A47/A11 Thickthorn Junction

Scheme Number TR010037

8.11 Statement of Common Ground with Big Sky Developments Ltd

**STATEMENT OF COMMON GROUND -
BIG SKY DEVELOPMENTS LTD**

Drawing Number: HE551492-GTY-LLO-000-DR-BL-30007	Rev: P05
--	----------

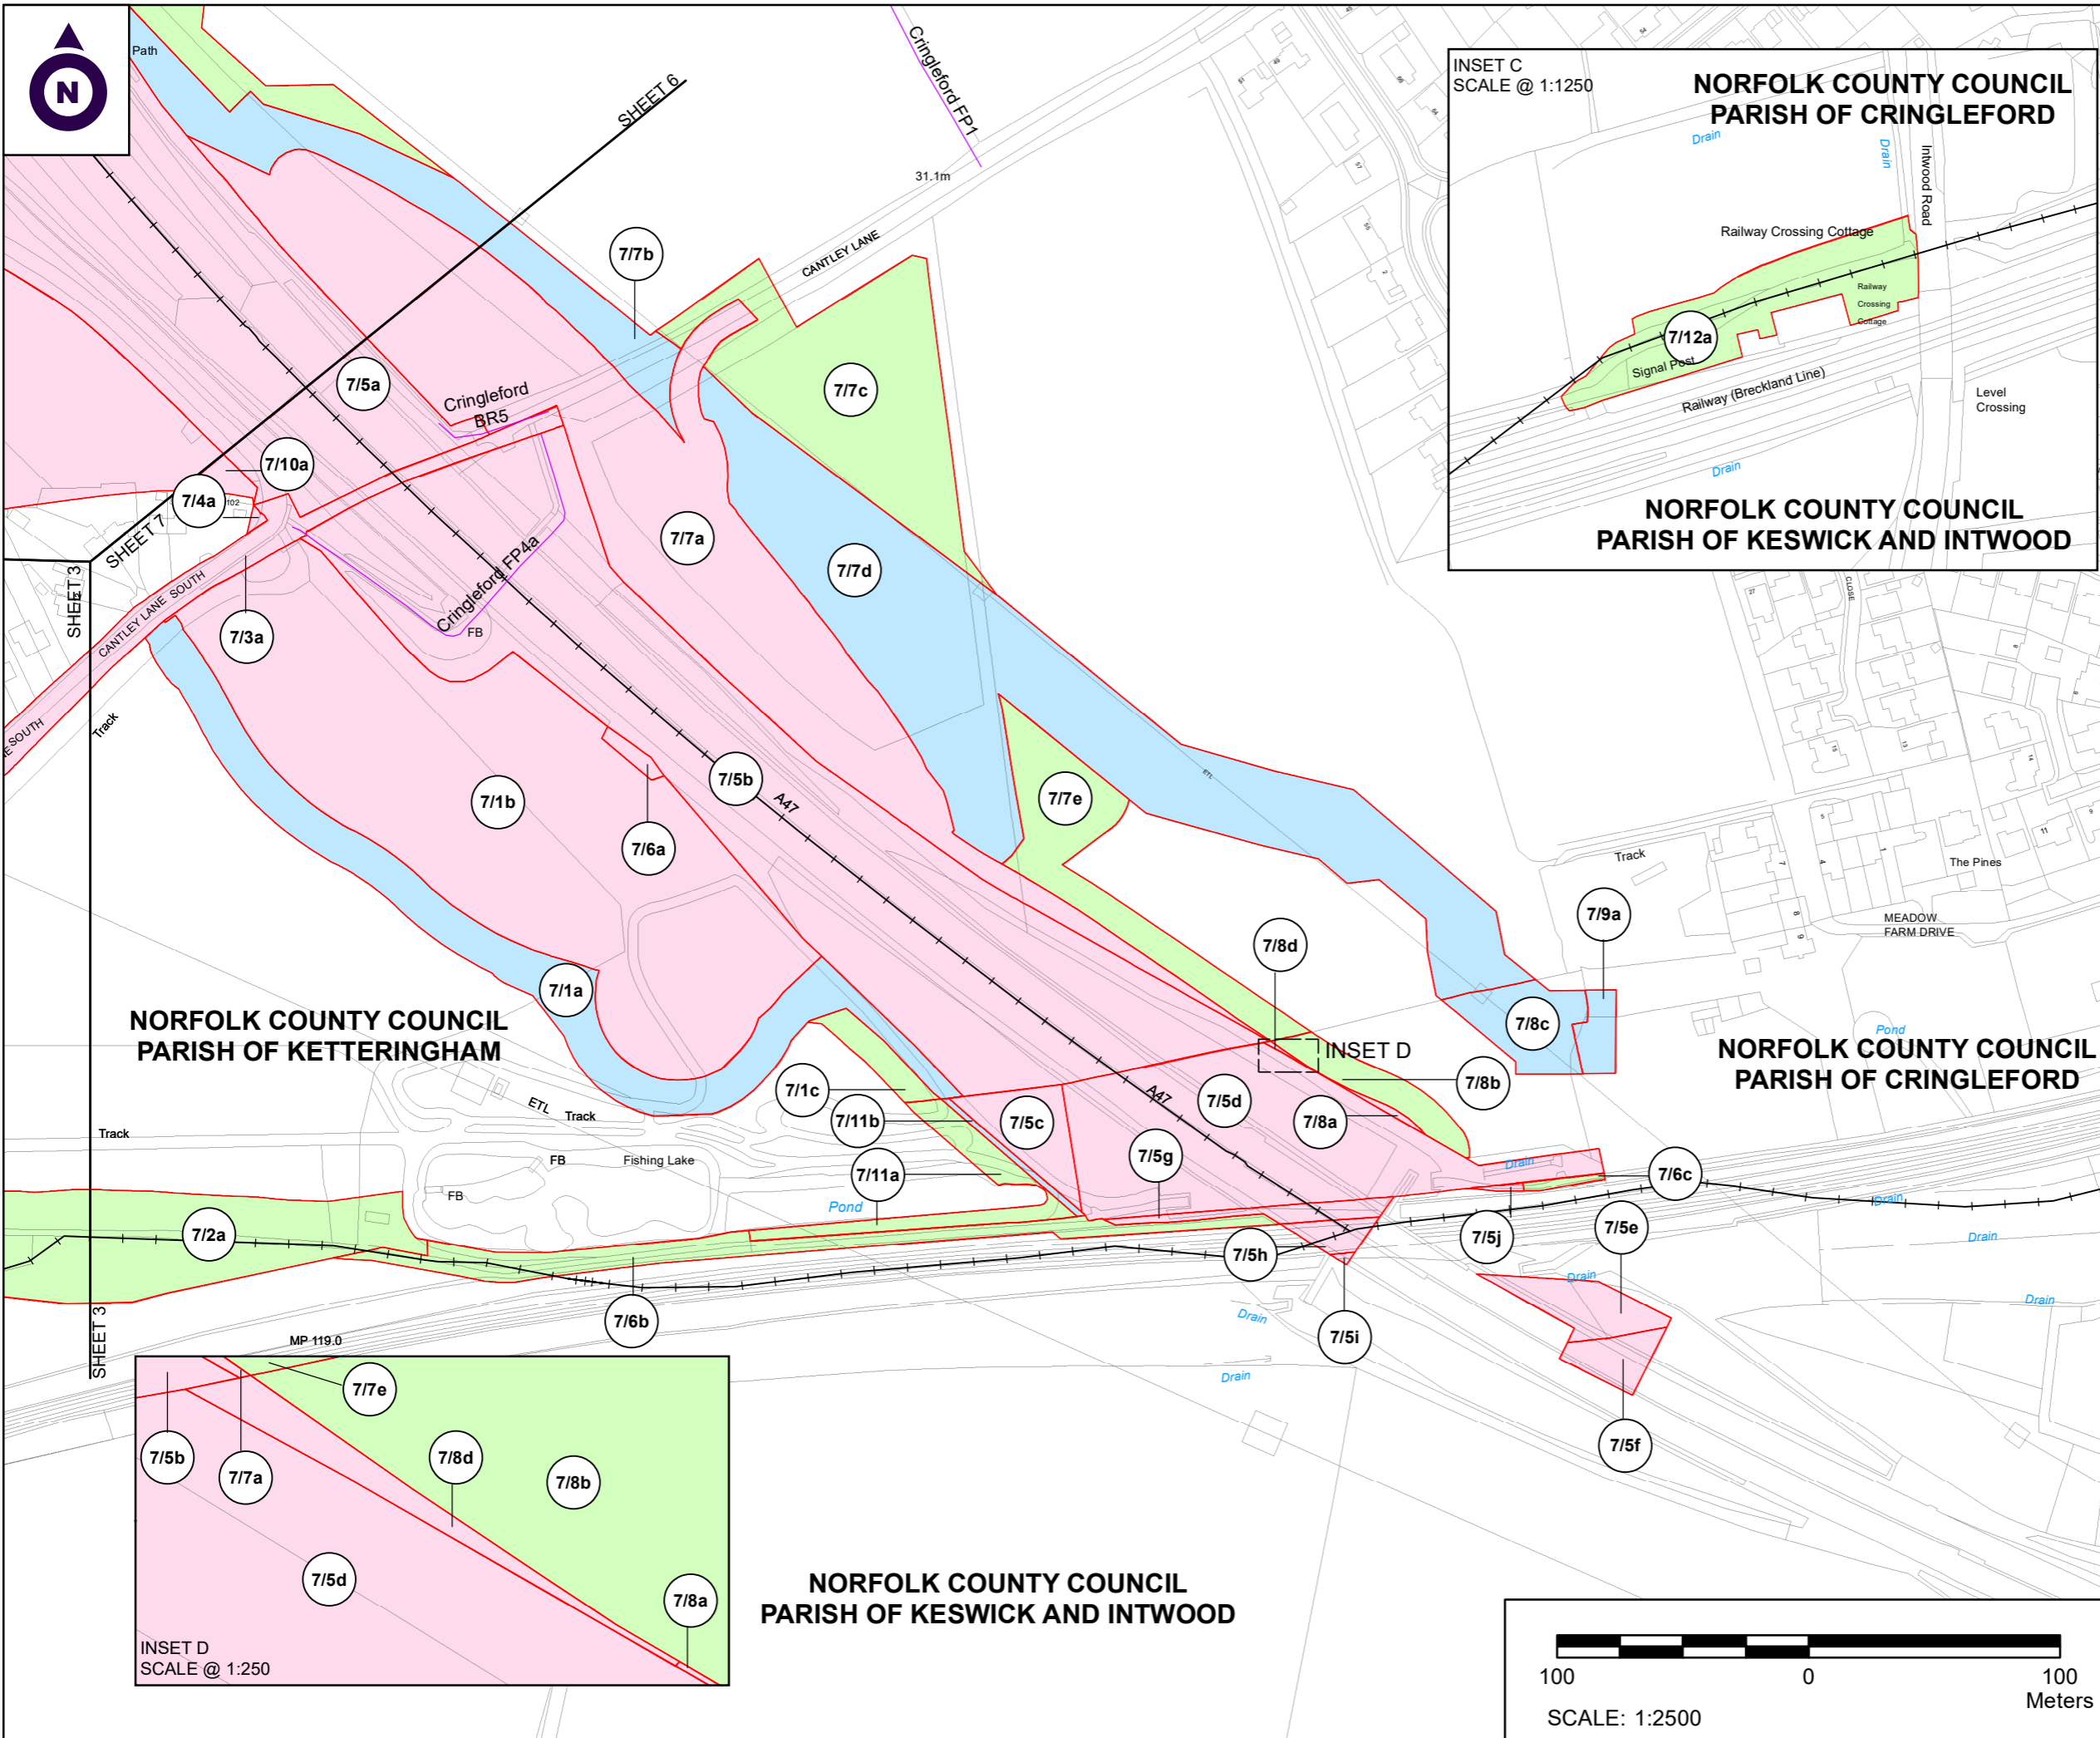
| 5 | Site Compound | | <p>The triangular compound reference 7/7c will occupy land designed for three houses and will affect the ones immediately north, as services and accesses cannot be completed, and the phase of the development cannot be completed. Our understanding is that timescales will coincide badly:</p> <ul style="list-style-type: none"> i. A47 Thickthorn Scheme timing Works from Early 2023 to December 2024, if there are no delays. ii. St Giles Park development timing. Phases 14 and 16 works from early 2023 - to be completed by Autumn 2024, with the development completed and contractors off site by the end of 2024. There was mention that the site would be used for welfare facilities rather than for the construction compound and material storage area referred to in the general arrangement plan. The contractor or the Applicant may indicate they require storage facilities on this site, but there is a significant area on land which is expected to be under the Applicant's control on the southern side of A47, shown on Plan 6 the PCF Environmental Masterplan <p>If the site (plot 7/7/c) is to be used for welfare facilities with portaloos and an office or welfare base, the site does not need to be 1.7 acres or so. This use could be accommodated along the hard surfacing of Cantley Lane, a closed off road used only for public access. Alternatively, the site could be restricted to the south of the overhead UKPN overhead pylon line which is reserved for public open space after completion. it would not prevent</p> | <p>Plot 7/7c is required for a site compound, welfare facility, parking and some storage. The Applicant will be able to confirm the exact area required once the detailed design has been prepared and will try to minimise the temporary land take in this area. However, the extent of land shown on the land plans is the land that is required to ensure the Scheme can be delivered at this stage of the design process. The Applicant is under a legal obligation to provide welfare facilities and this is the only area where these can be provided, whilst complying with the Construction (Design and Management) Regulations 2015.</p> | Under discussion | |

| | | | <p>construction, and interference will be time limited. If the Applicant can persuade their contractors, or they can be pressurised to omit this area of conflict or time limit their occupation, we request that a deadline is set for removal of the compound from the land so the landowners can provide guarantees to buyers.</p> <p>If the site is to be used for a construction compound the impact is greater. We remain concerned about the proximity of works and the impact of the compound on new adjacent residential properties, but this is much more severe if houses cannot be built at all. We are concerned about the planned exit from site by Autumn 2024 as the Thickthorn works are also designed to complete then. The owners will be prevented from selling in advance and from building through the period proposed through 2023 and 2024. This produces problems of breach of contract, penalties, and preliminaries.</p> | | |
